**WEST SUSSEX COUNTY COUNCIL
INFRASTRUCTURE CONSULTATION**

SUBJECT: P/119/09- Conversion of part of the property to provide short term letting for paying guests.

2, Old Sefter School House, Pagham Road, Bognor Regis, PO21 3PX

PROPOSED SITE PLAN

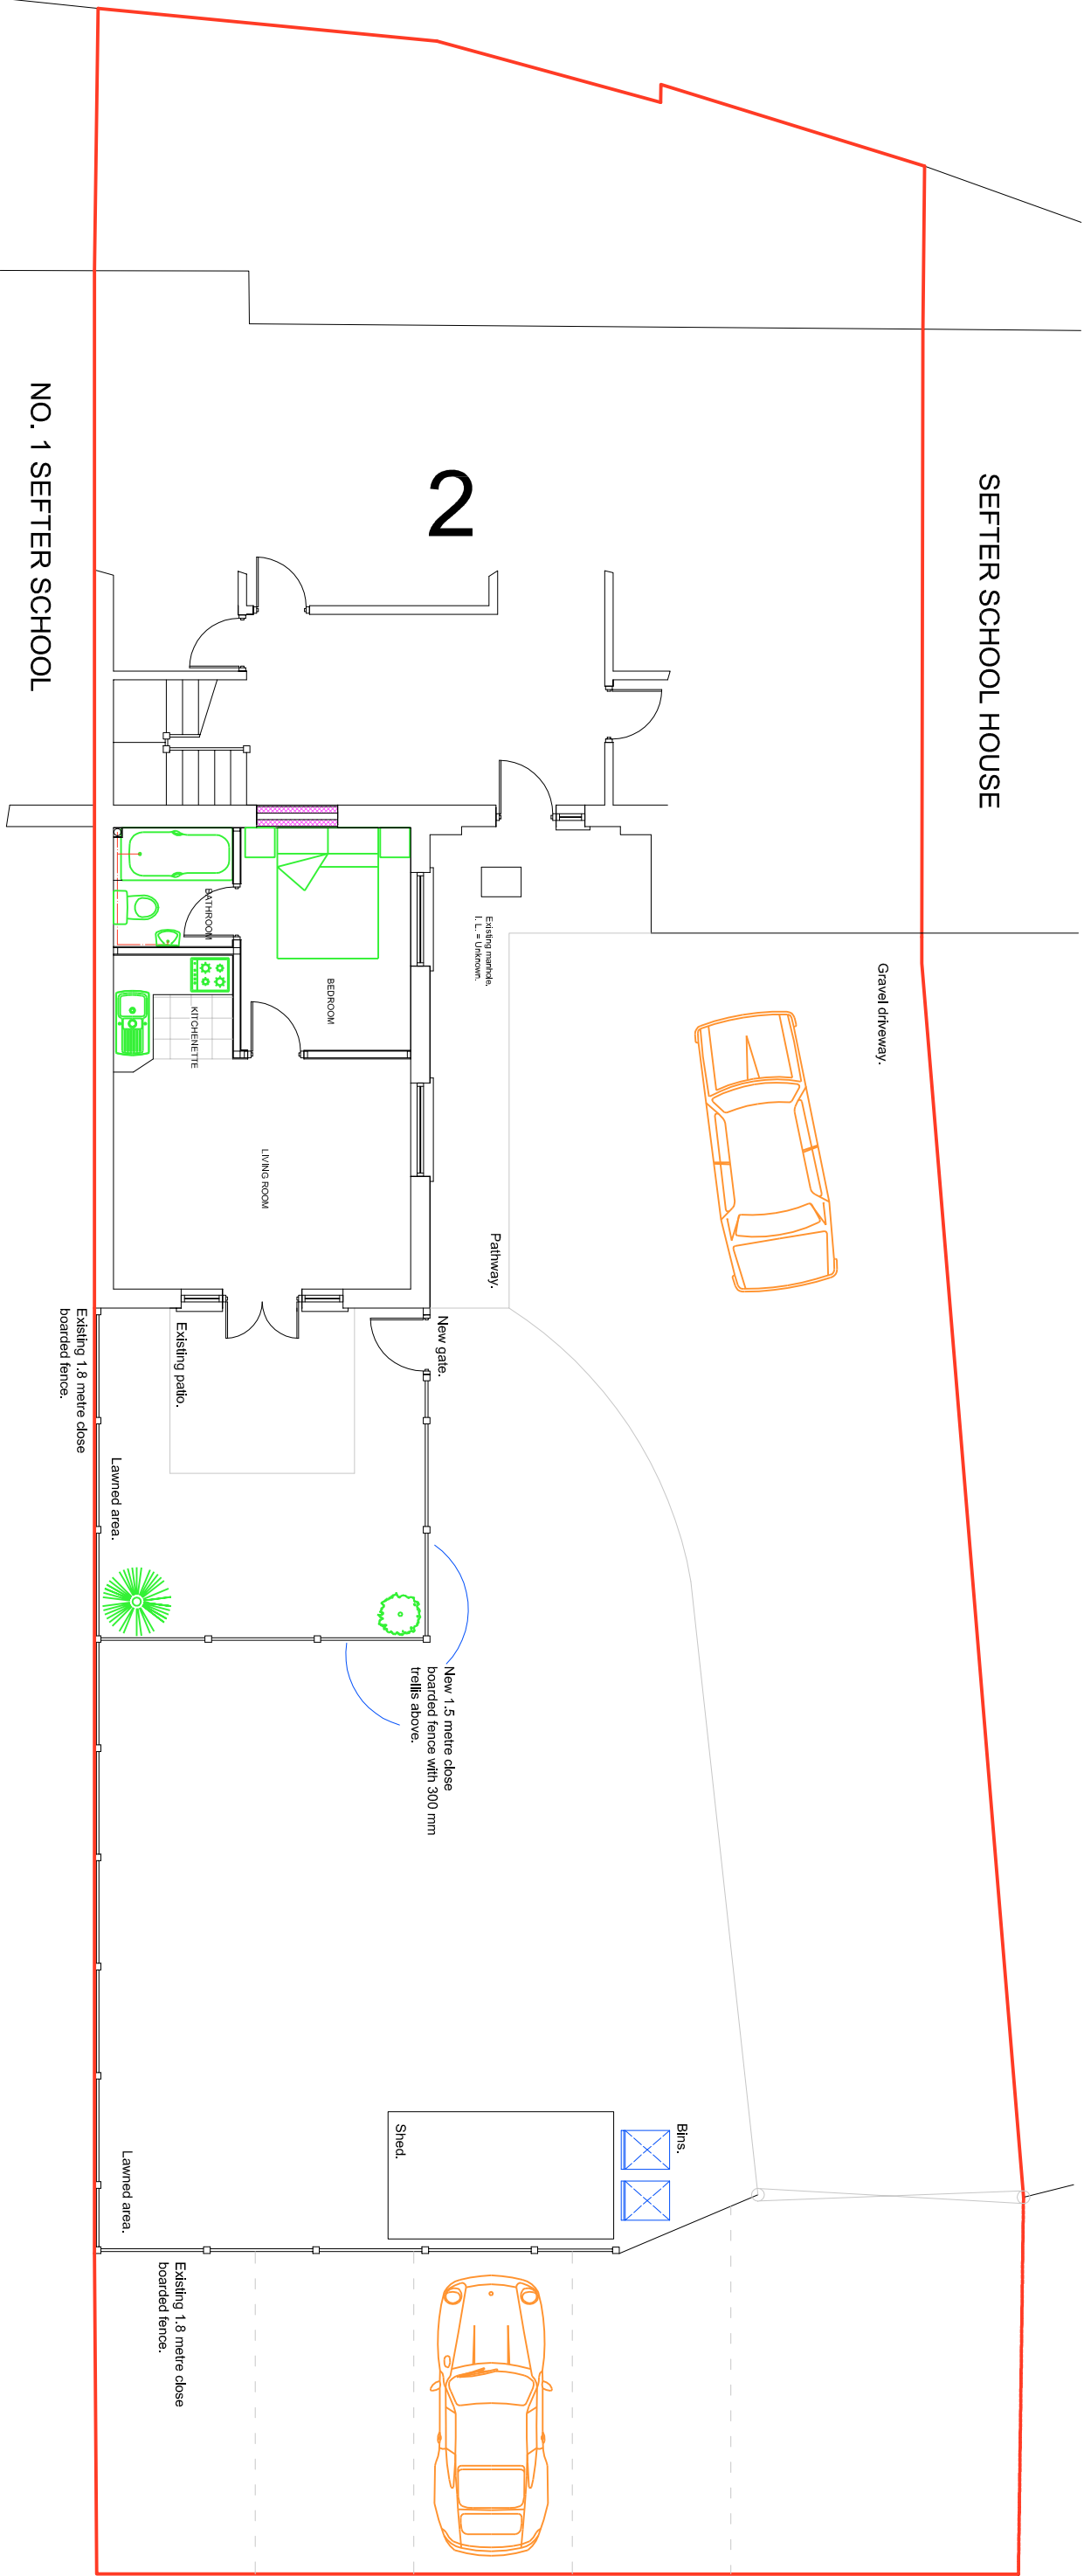
The applicant would be required, to provide cycle parking at the site for staff and visitors to discourage the use of a private car where possible, this should be secured by condition.
